Part 5 of the Town & Country Planning (Development Management Procedure) Order 2015
Approval of details reserved by condition imposed under ref. BE/135/18/PL relating to
Condition No. 14 (full permission) regarding details of the maintenance and management of
the surface water drainage system at the Salt Box site.

Land at Salt Box, West of Shripney Road, Bognor Regis

Arun District Council have decided to **REFUSE details reserved by this condition**

Title: UNITS 4, 5 AND 8 DRAINAGE LAYOUT

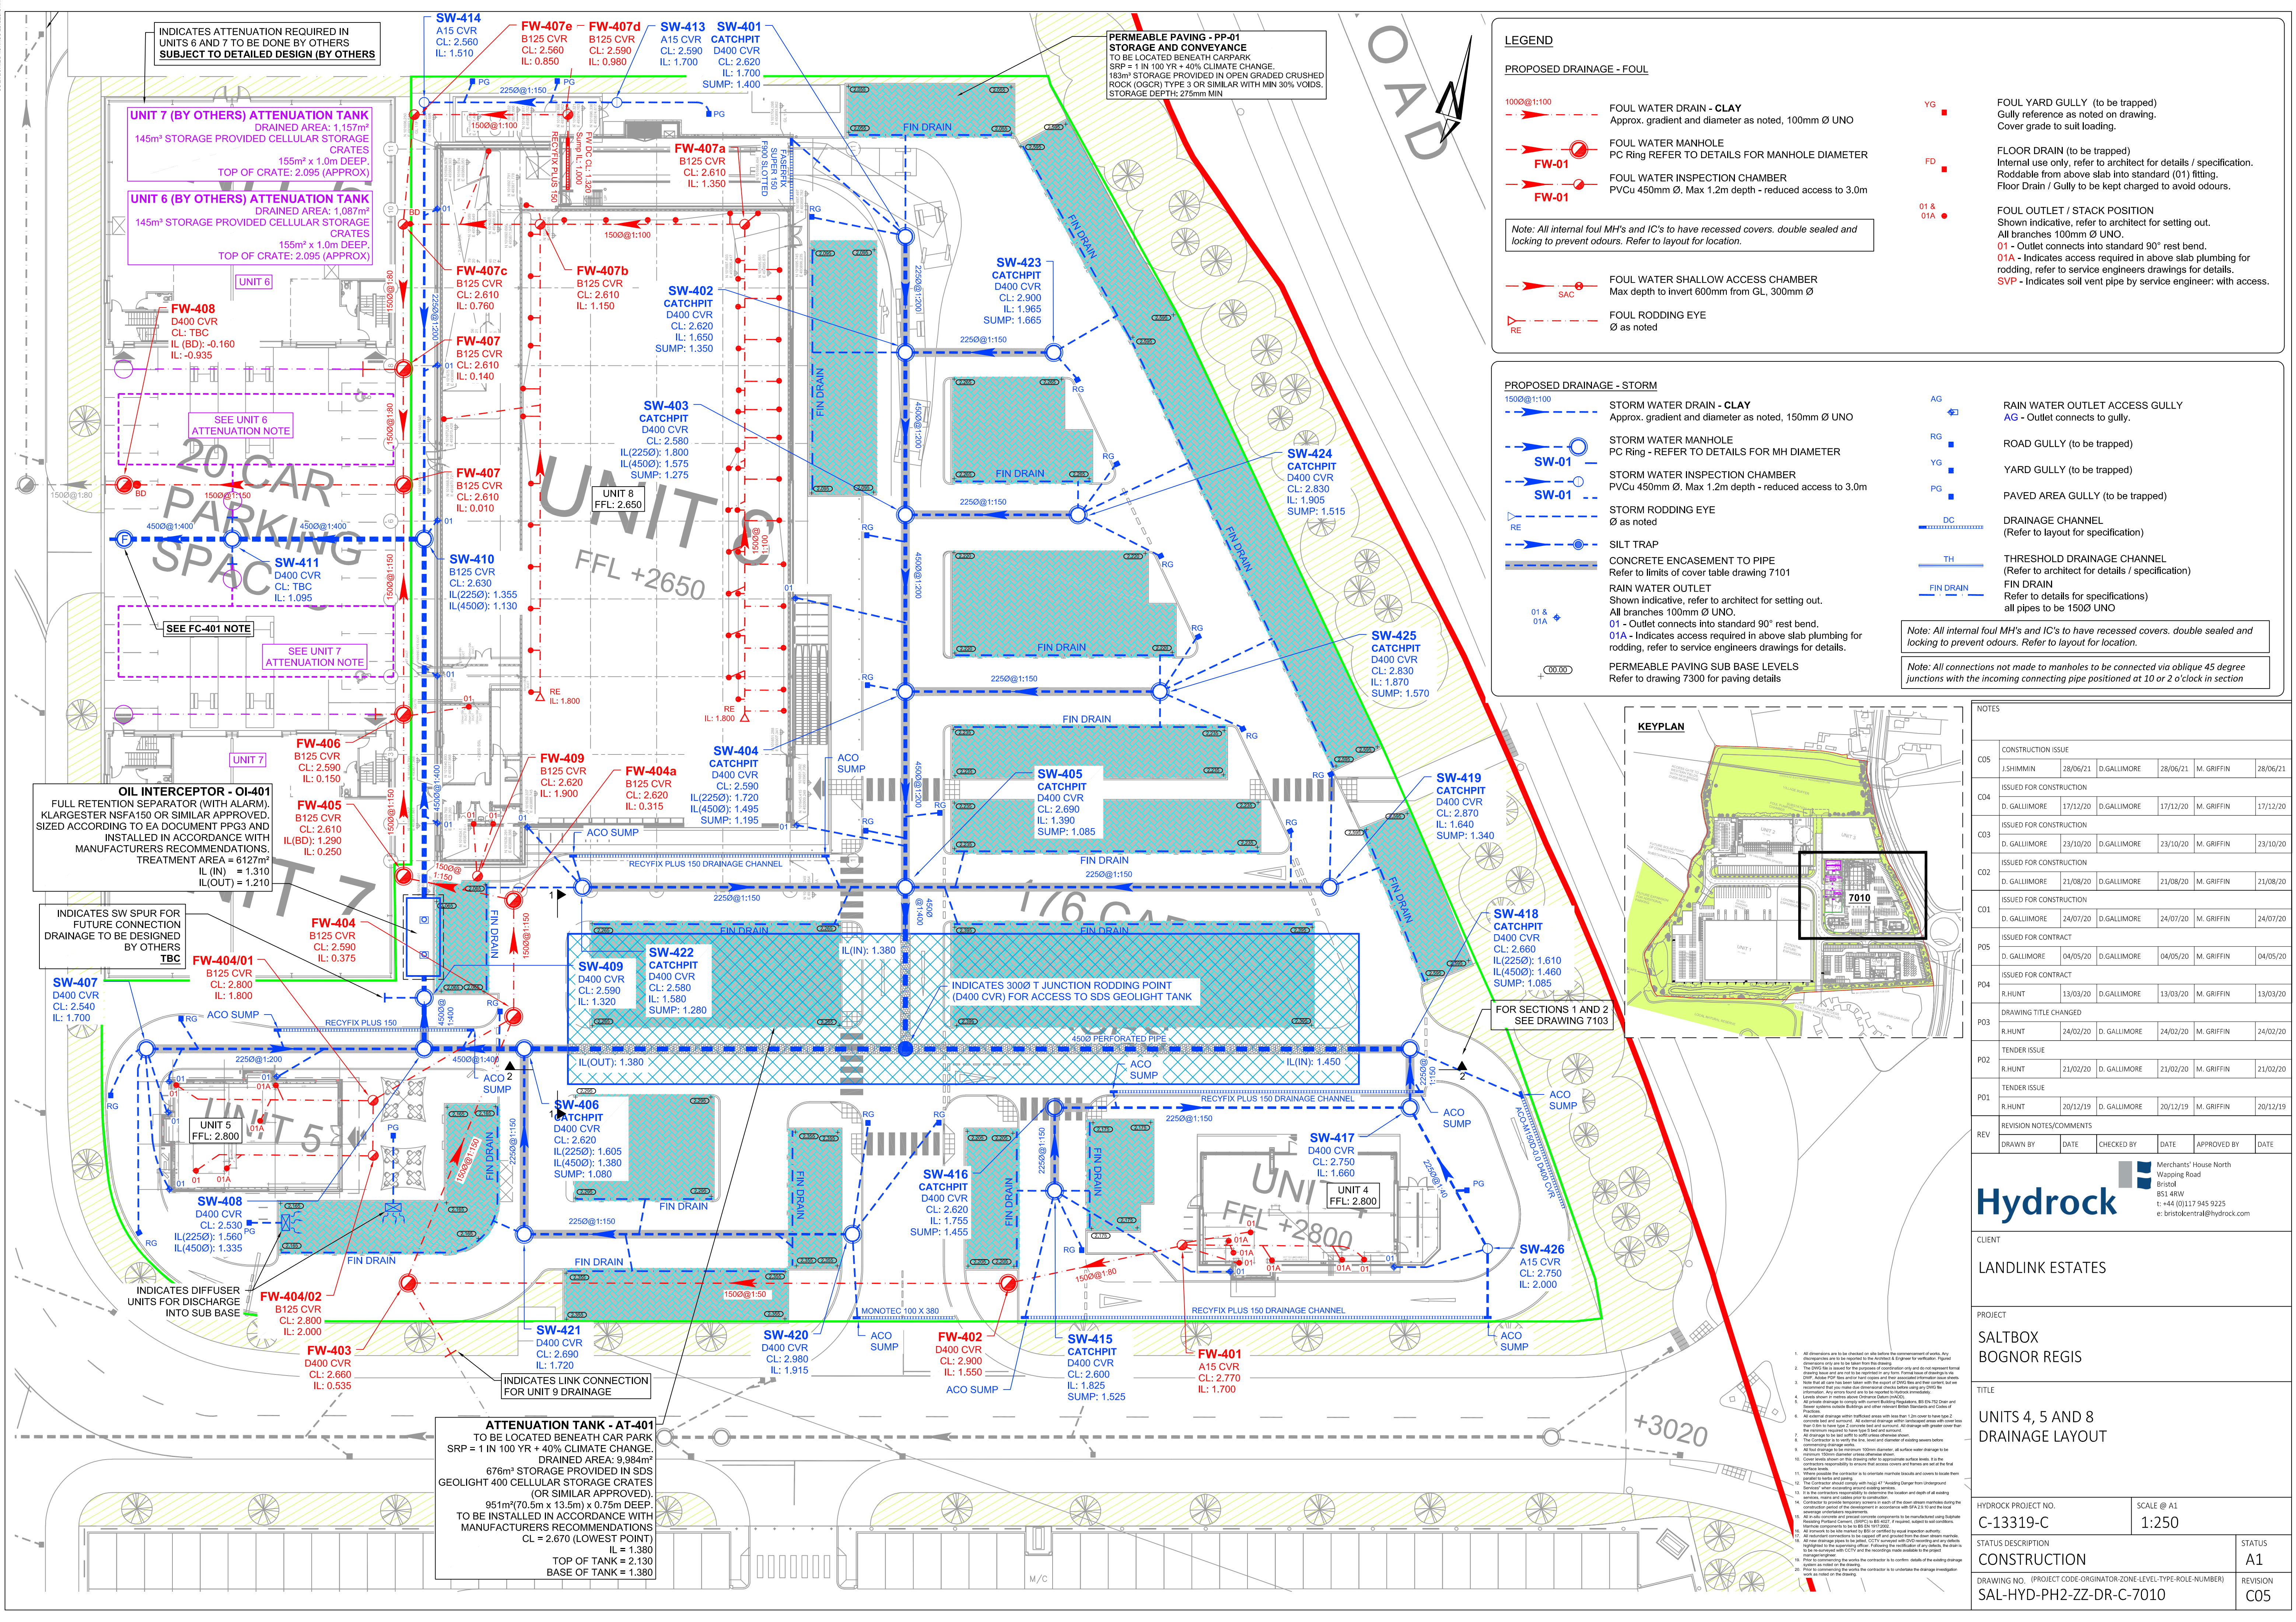
The information submitted regarding Condition 14 imposed on the full planning permission relating to details of the maintenance and management of the surface water drainage system at Units 2, 4, 5, 6, 7 and 8 at the Salt Box site is refused and the condition is hereby not discharged.

It is evident that substantial changes have been made to the drainage since the approval. A review of these changes has been completed. Levels at some manholes are considerably different between the approved design and as built drawings, the difference in levels is in excess of 50mm in some areas. It appears that at one location an outgoing invert is significantly above the incoming invert to the chamber, and in others downstream inverts are higher than the invert levels of upstream attenuation crates.

Pipe diameters and slopes have not been confirmed. If the fall of a pipe is different over its length, but the distance is the same, the slope of the pipe simply cannot be the same. Gully locations and levels have changed from those designed, gully cover levels have not been labelled on drainage plans.

The type of channel drains constructed are different to that approved. Details of the exact channel drains constructed have not been supplied to evidence that these are suitable for the loading conditions and are appropriately sized to drain their catchment areas.

UNITS 1 AND 9
DRAINAGE LINK SHEET 2

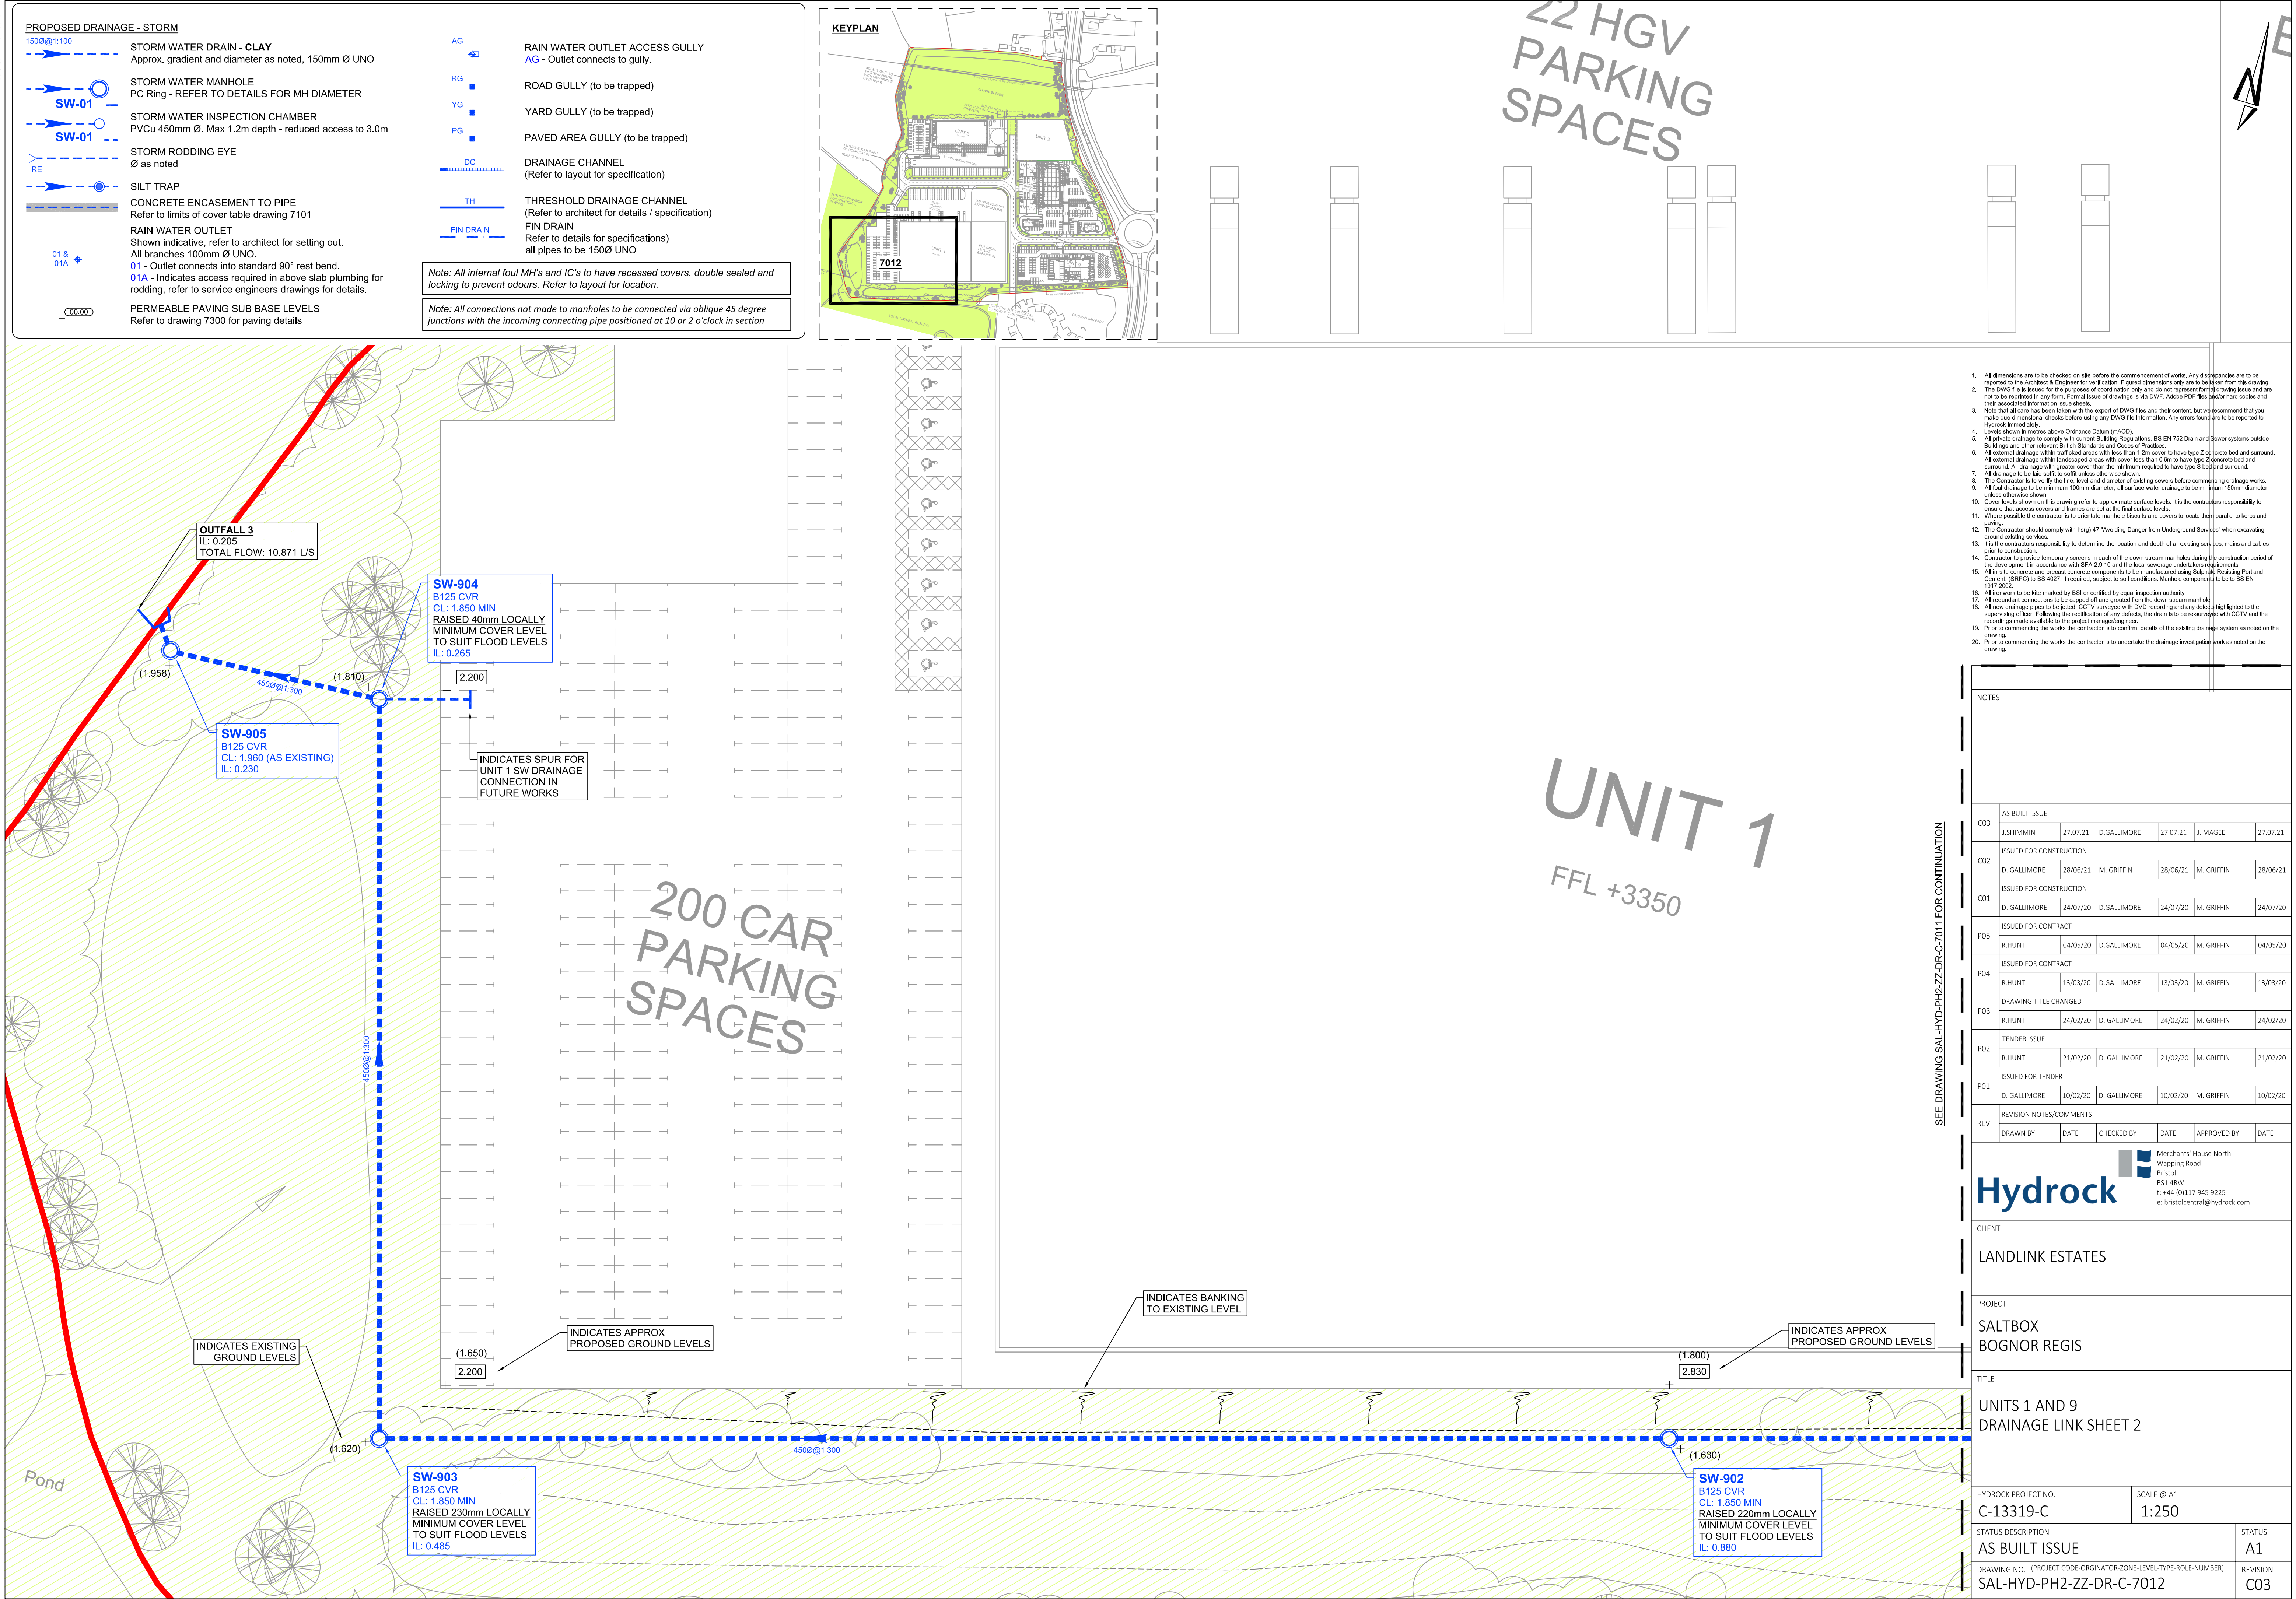
Due to the number of discrepancies and the potential significance of these the surface water drainage network would need to be remodelled and updated calculations would need to be provided to demonstrate whether the drainage as constructed meets policy requirements.

TITLE
UNIT 2 DRAINAGE LAYOUT SHEET 2

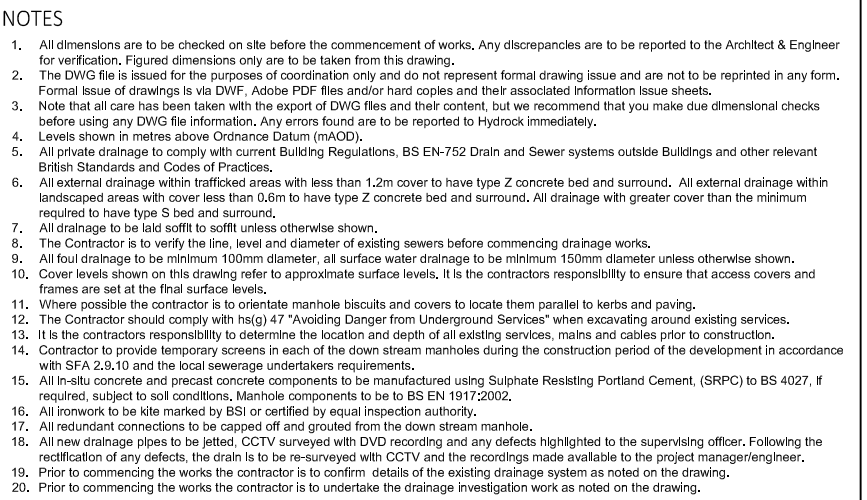
The headwall angles have been altered since approval. No evidence has been submitted to prove that the relevant consents (FRAP and Land Drainage Consent) apply to the revised headwalls.

The information presented is insufficient to evidence that the as-built drainage meets policy requirements, contrary to Policy W DM2 and Policy W DM3 of the Arun Local Plan and the National Planning Policy Framework.
